CITY OF ALBUQUERQUE

December 20, 2018

RE: Legacy Apartments – Phase I
6501 Alameda Blvd NE
Engineer's Stamp Date: 09/15/16
Engineer's Certification Date: 12/12/18
Hydrology File: C18D064B
CPN #742484

Based on the Certification received 12/14/18, the Engineer's Certification **is not** approved for ROFG/SIA for Hydrology. The following comments need to be addressed for approval of the above referenced project:

GRADING AND DRAINAGE PLAN

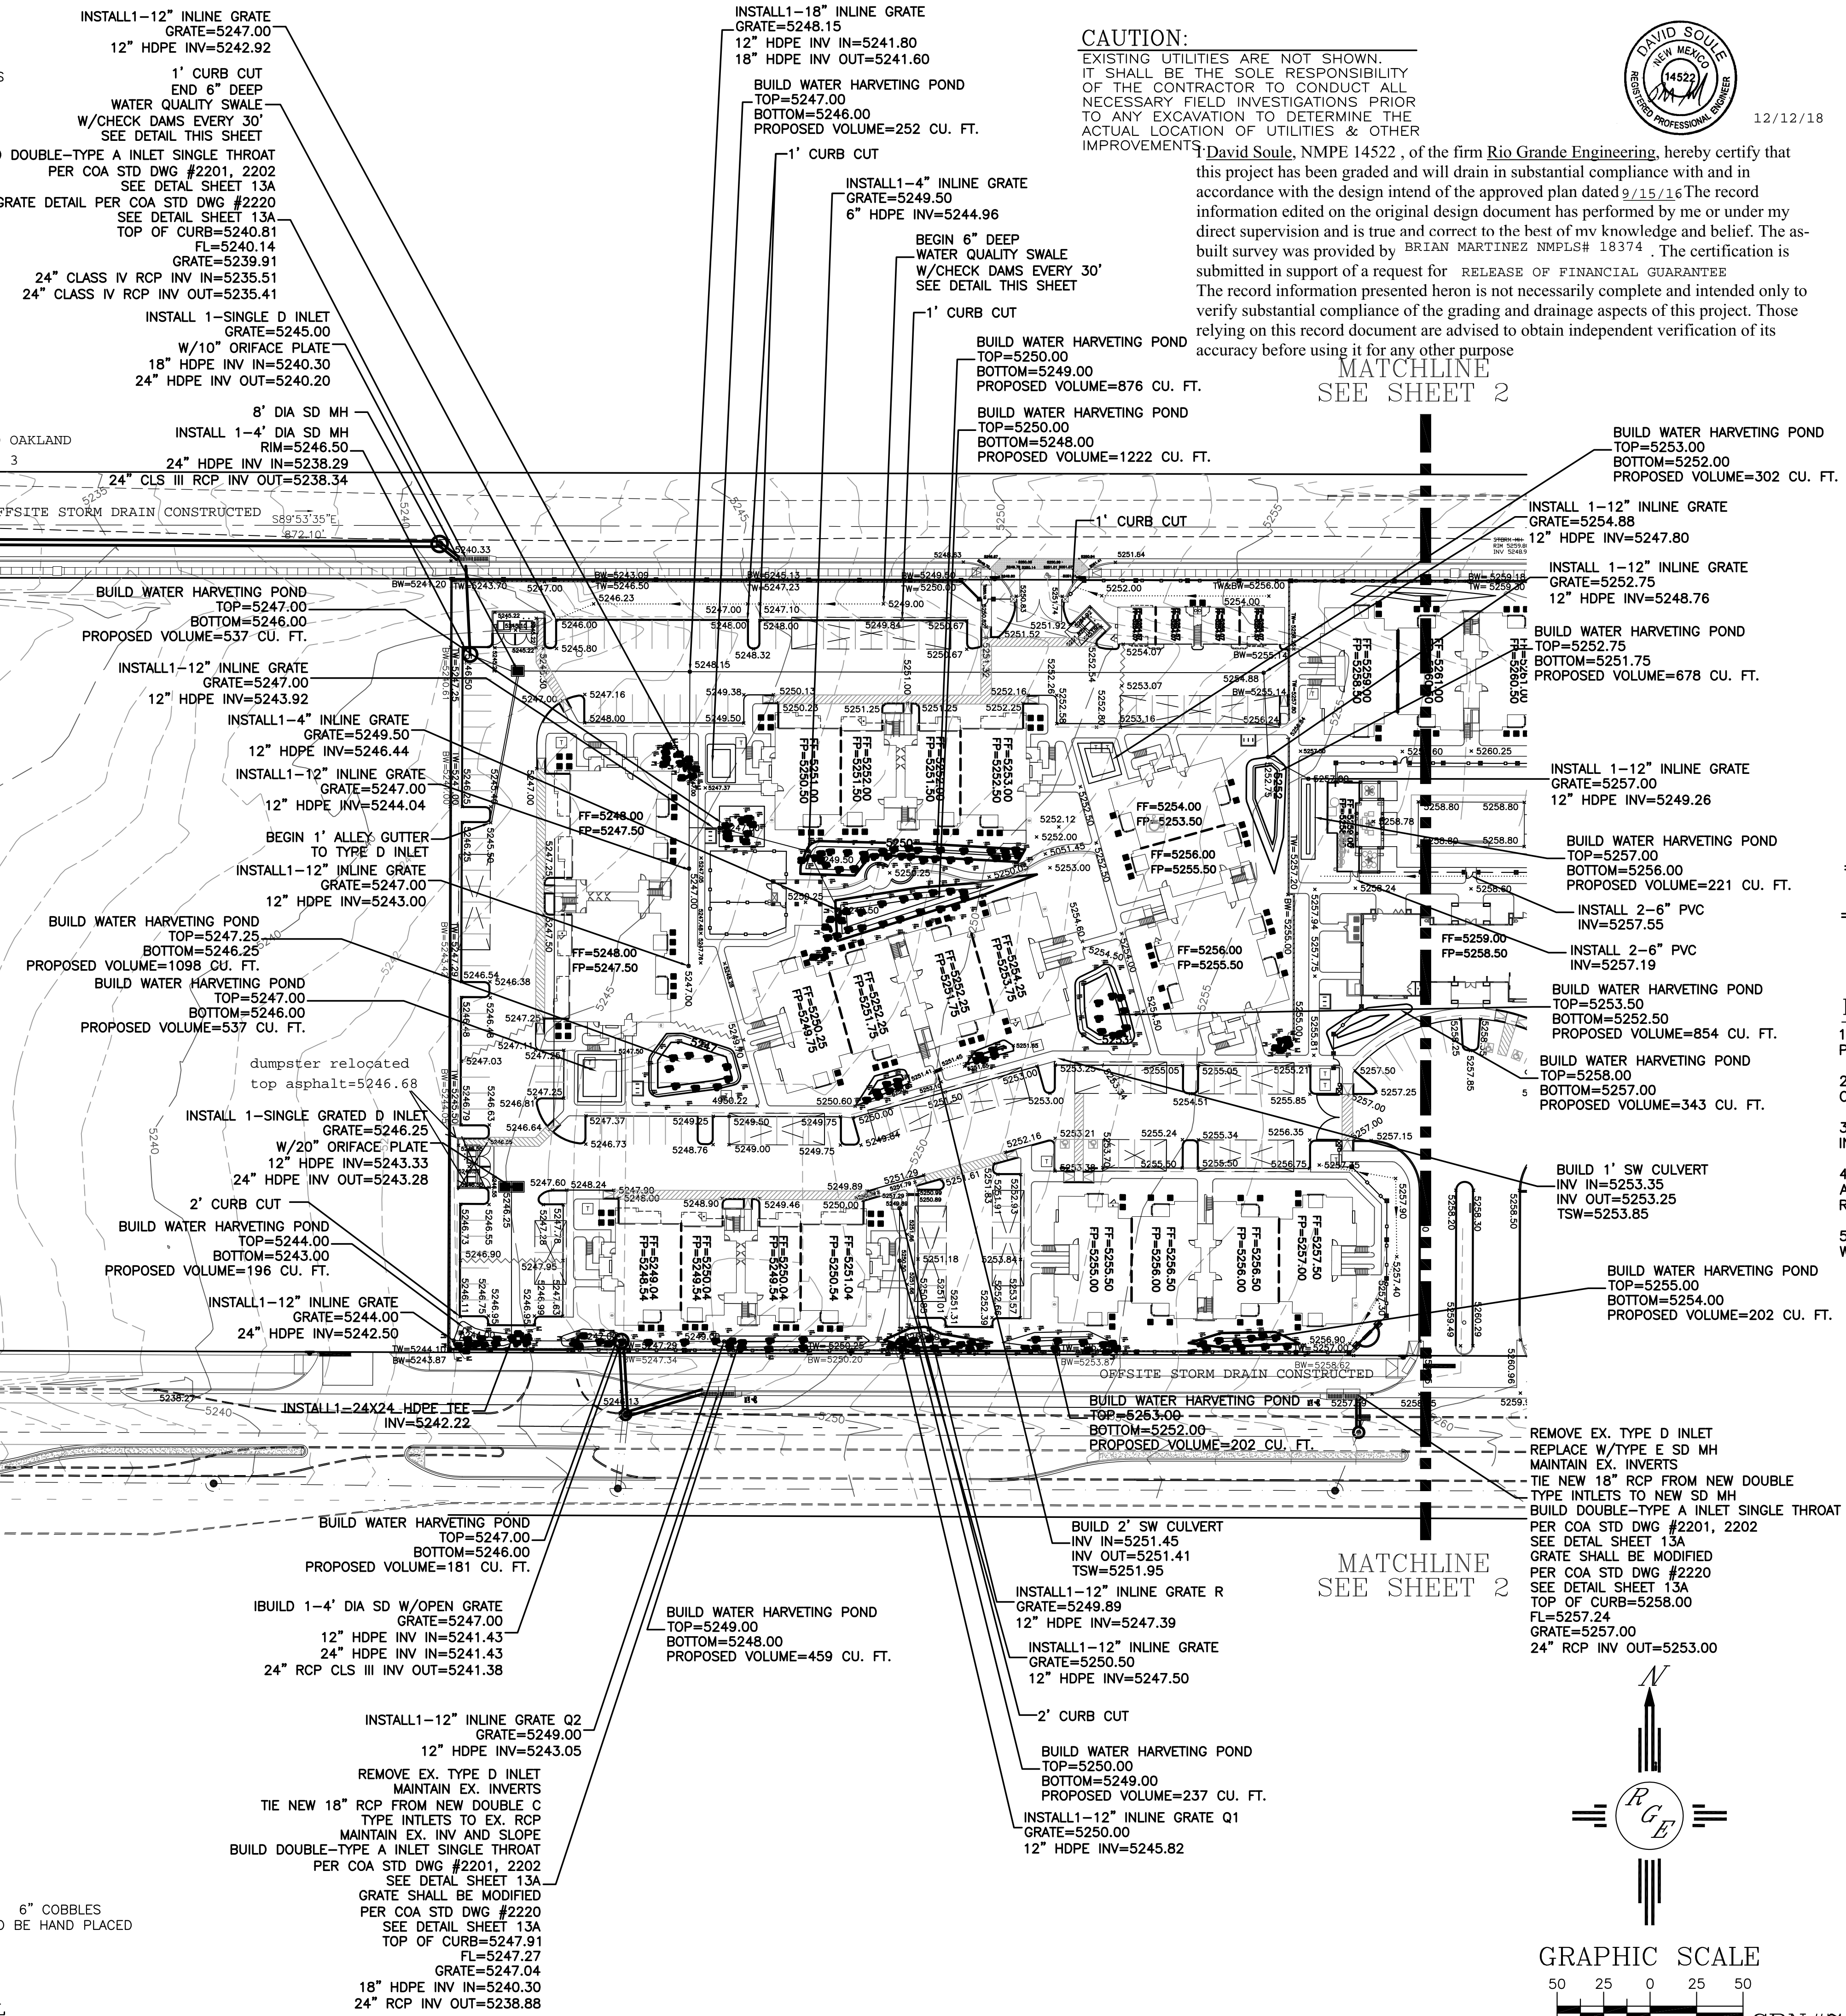
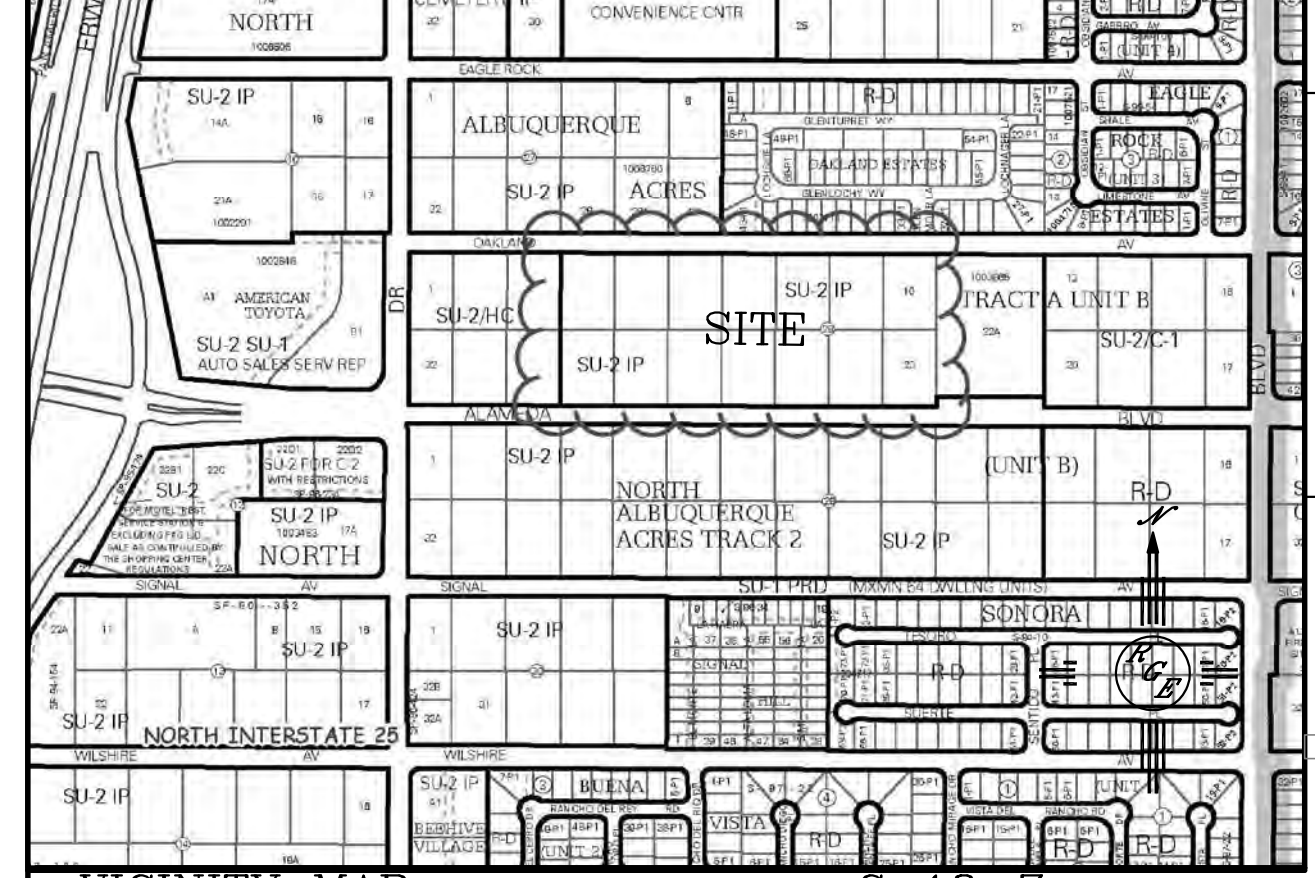
1. The inlet near the corner of Oakland and San Pedro needs to be constructed. It was discussed back in May 2018 that this inlet is to be constructed with Legacy Apartments – Phase II. However, this inlet is not on their Infrastructure List so the financial guarantee for the inlet is solely on Legacy Apartments – Phase I.

The current IIA does not expire until May 2018. So there is some time for the inlet to be constructed by Legacy Apartments – Phase II. Once this inlet is built and approved by the City, the request for FOFG can be resubmitted. At that time no fee will be assessed for the resubmittal.
